Your ref:  
Our ref: 21/00979/F  
Please ask for: Mrs Rebecca Bush  
Direct dial: 01553 616825  
Direct fax: 01553 616652  
E-mail: borough.planning@west-norfolk.gov.uk

Details: **Extension and loft conversion at Cassiobury 31 The Green North Runcton  
King's Lynn Norfolk**

I have received a planning application as detailed above but cannot process it until I receive some more information:

Proposed Elevations

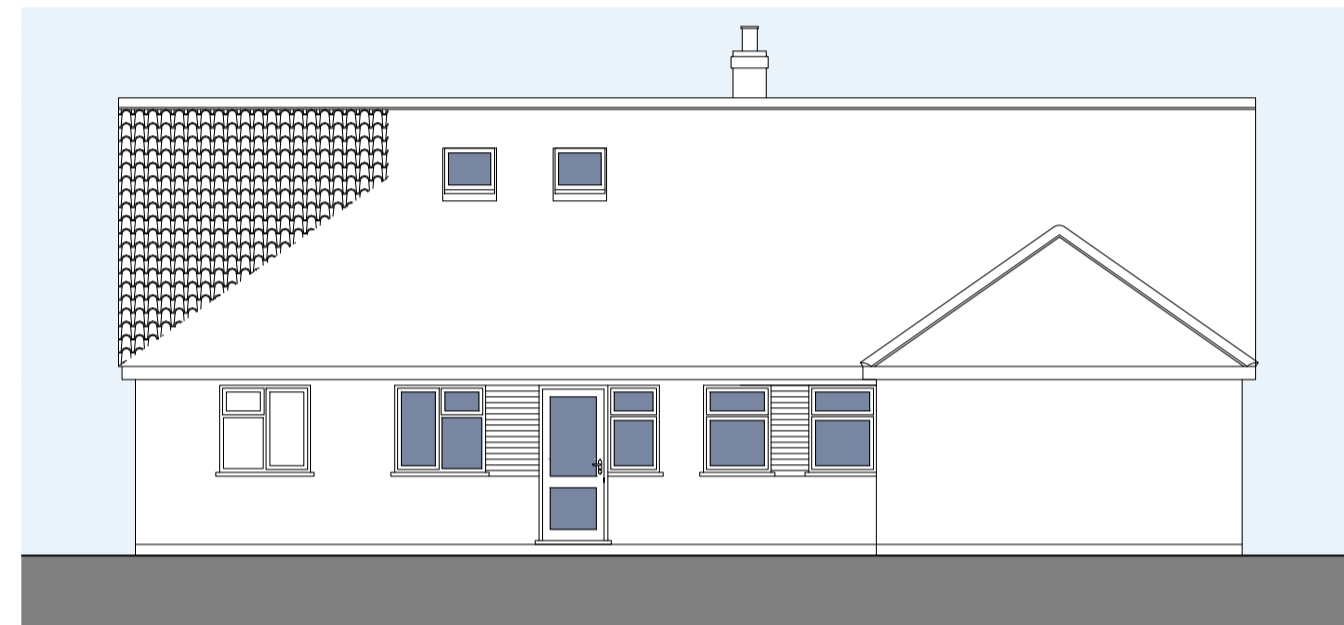
1. The proposed north elevation shows 2 roof lights however the roof plan only shows one, please amend where necessary.
2. As the property lies within an area at risk to flooding, please complete the simplified Matrix and return it. The Matrix can be found at [https://www.west-norfolk.gov.uk/info/20173/information\\_for\\_planning\\_agents/231/flood\\_risk\\_information](https://www.west-norfolk.gov.uk/info/20173/information_for_planning_agents/231/flood_risk_information)
